Application for a non-material amendment following a grant of planning permission.

Number	78
Suffix	
Property name	
Address line 1	Langbury Lane
Address line 2	
Address line 3	
Town/city	Ferring
Postcode	BN12 6QE
Description of site location must be completed if postcode is not known:	
Easting (x)	509066
Northing (y)	103333
Description

Single storey rear side ground floor extension, first floor dormer extension, alterations to east & west doors, change of glass to obscure in all bathrooms, infilling rear dining room glass with brick & relocation of shed.

Reference number:	FG/65/18/PL
-------------------	-------------

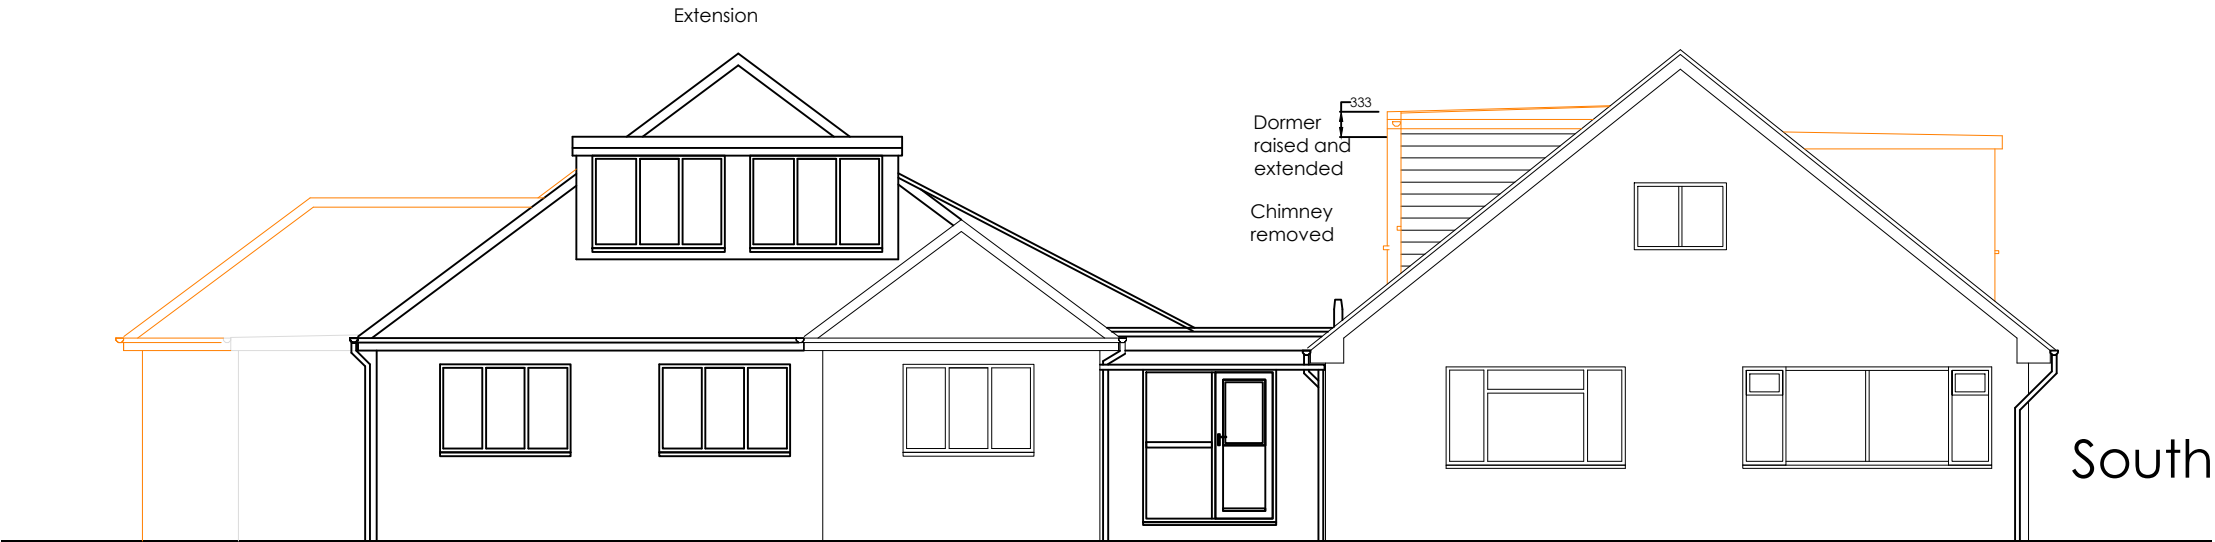
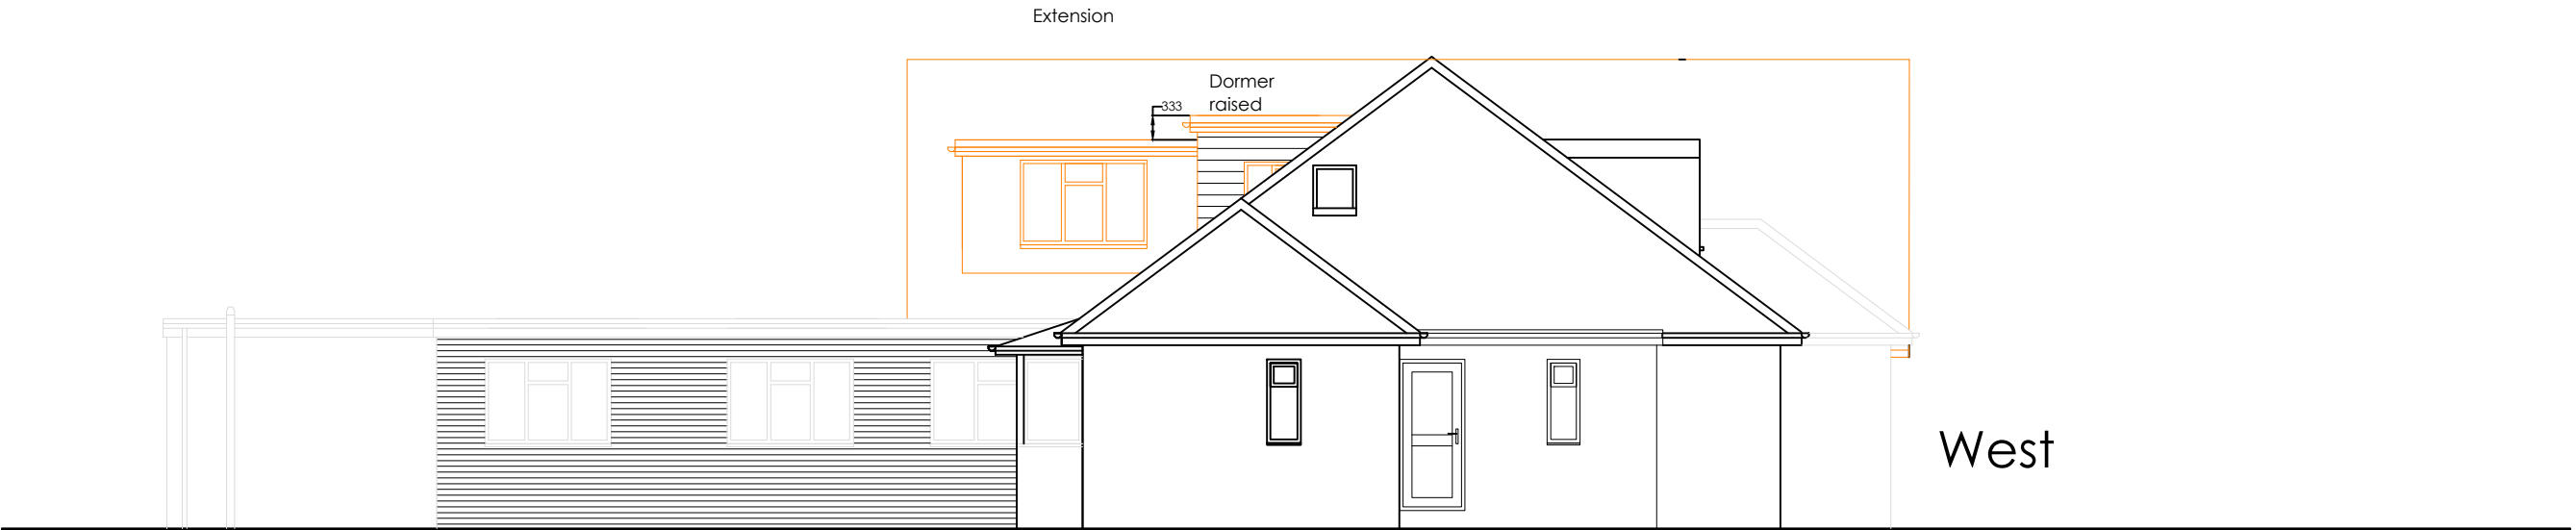
Alter window to east elevation ground floor bedroom 3A to fire escape door and window

Door required by Arun council building control for means of escape
